DOC18/942089  
SSD 09\_0103

### **Boco Rock Wind Farm Modification 1 Environmental Assessment**

As requested, we have reviewed Boco Rock Wind Farm's Modification Application (Mod 1) Environmental Assessment (EA).

**Figure 3: Proposed modification to Yandra cluster, 2018**

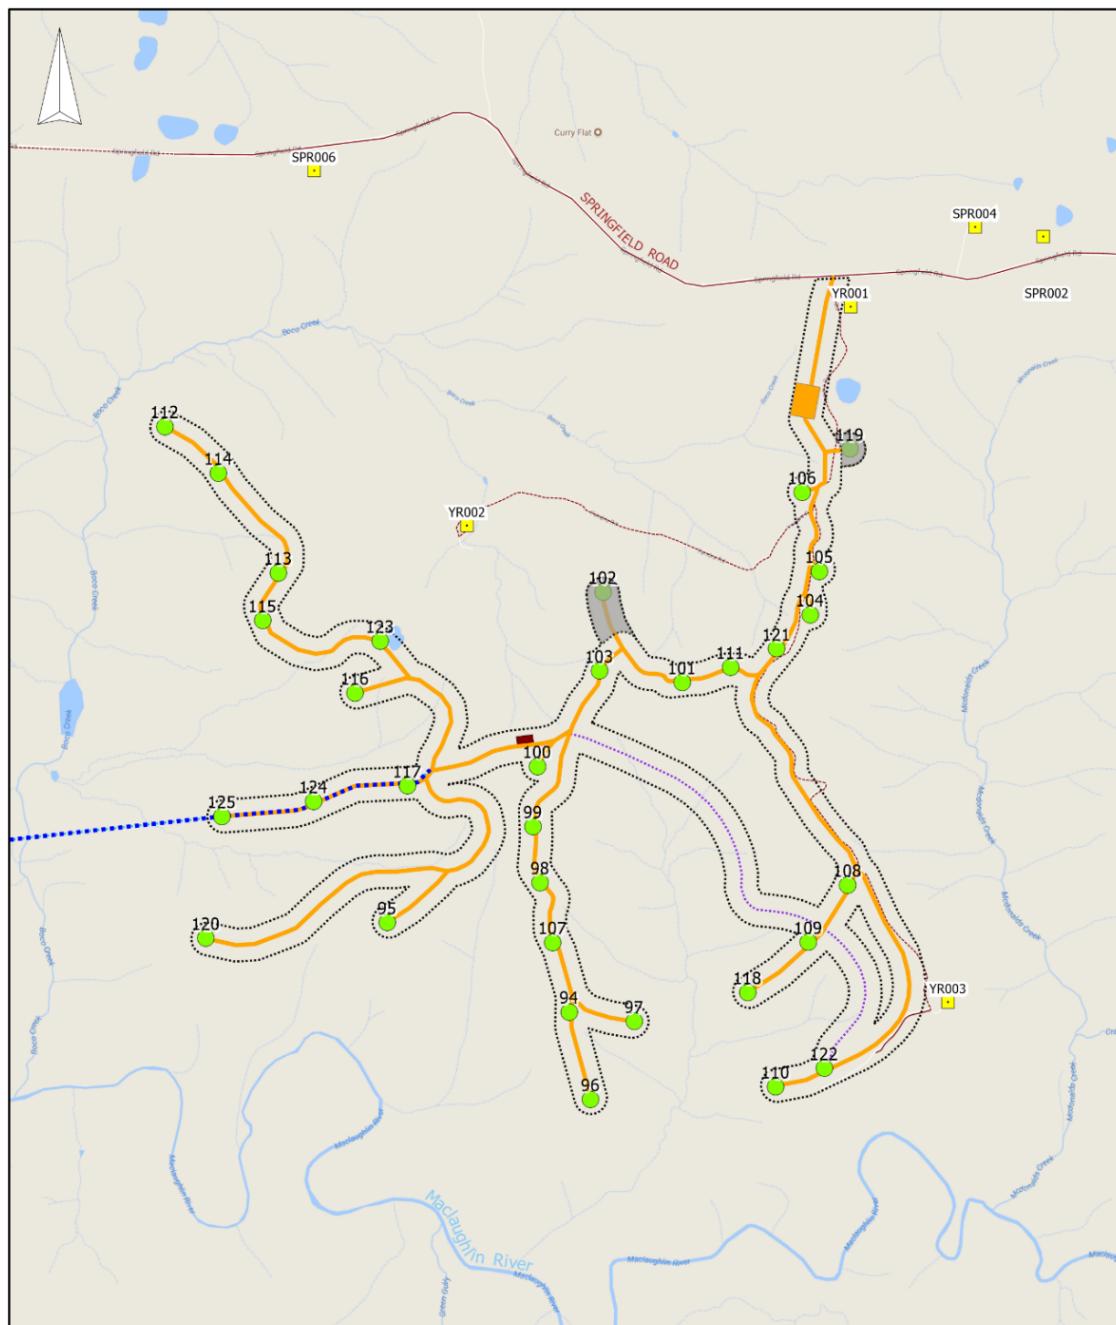
There will be a 48% increase in the RSA in the Yandra cluster of 130,288 m<sup>2</sup>. Bird and bat strike is a prescribed impact in the BAM, and should be assessed accordingly. While the Mod states that this is an increase of 8% in RSA across the entire wind farm, it is a significant increase in impact at Yandra. The Yandra cluster is situated in a patch of Ribbon Gum – Snow Gum open forest with a much higher proportion of trees than Stage 1 of the wind farm, providing very different fauna habitat

The EA states that the impact of the roading will be halved as the road width will be reduced to six metres reducing the impact by 13.2 hectares of road area. The EA states that this reduction is based on the developer's experience constructing stage 1 (page 10). However, it is difficult to understand how this can be the case as the rotors are much longer than those used in stage 1 and OEH staff observed road widths of 20-30 metres on this wind farm when attending a compliance inspection on 17/12/14. We are concerned that these adjustments may not be realistic and that the reduction in clearing may be significantly over-estimated.

OEH notes that Appendix G (transport assessment) shows no change to the approved road width of 12m (page 6).

It is unlikely that the fringing disturbance area along roadsides will be rehabilitated to its original vegetation type, thus making them permanent impacts. Cut and fill and shoulder areas should also be considered in impact calculations.

We recommend that clarification be sought as to exact road widths and total vegetation clearing.
